**SUBMISSION TO THE DEPARTMENT OF PLANNING AND INFRASTRUCTURE ON THE PROPOSED
NORTH WEST RAIL LINK (NWRL)**

Name: ROGER HOOPER

Application Number: SSI-5100

Figure 6.11 Cheltenham Services Facility light vehicle access and egress

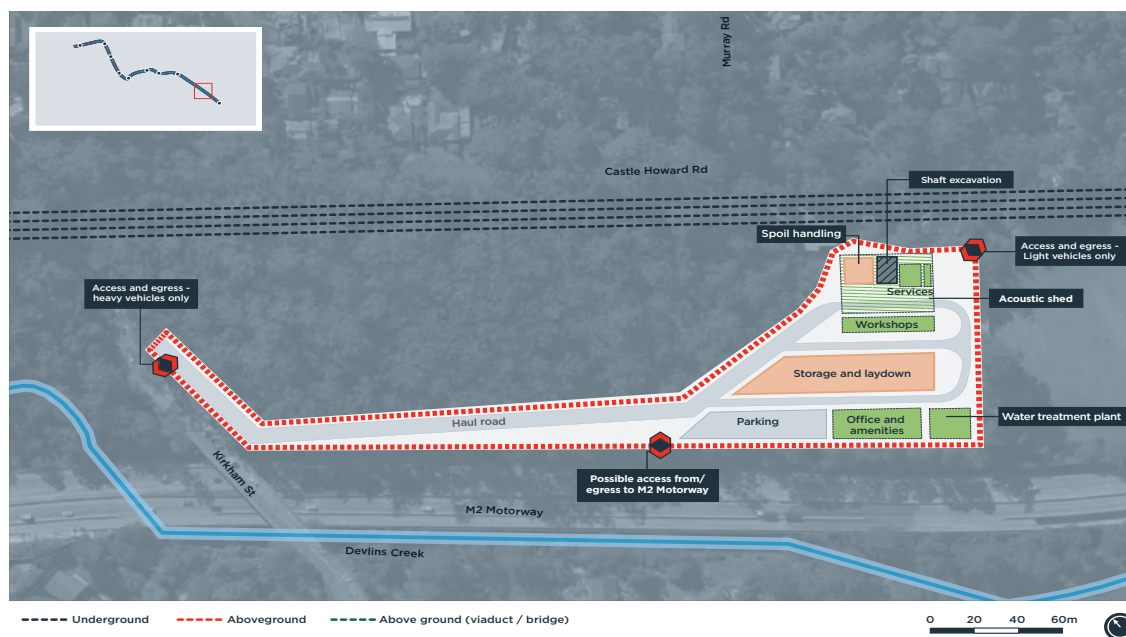
1. The option to construct a new two lane paved road through the Castle Howard Conservation Reserve to Kirkham Street (or Castle Howard Road) near the bridge over the M2 to allow trucks to remove spoil during construction and light vehicle access during operation of the facility will permanently destroy valuable Blackbutt Gully forest.

5. Should the roadway be built, the local streets (Kirkham Street, Castle Howard Road, Murray Farm Road and the bridge over the M2) are narrow, winding and congested and would not be suitable for trucks and, in the event of an emergency, large numbers of emergency vehicles.

6. There are no traffic lights at the corner of Kirkham Street and Beecroft Road. This is a dangerous intersection for traffic and pedestrians and would not be suitable for trucks and emergency vehicles.

I therefore ask that you adopt the alternative option of access to the site for construction and emergency vehicles be via new on and off ramps from the M2 motorway. The current widening and reinstatement of the breakdown lane should allow this access. It is the only practical way to move trucks in and out of the site. In the event of an emergency, many emergency vehicles would need quick access to the site from areas outside Beecroft and Cheltenham as it only has one fire engine.
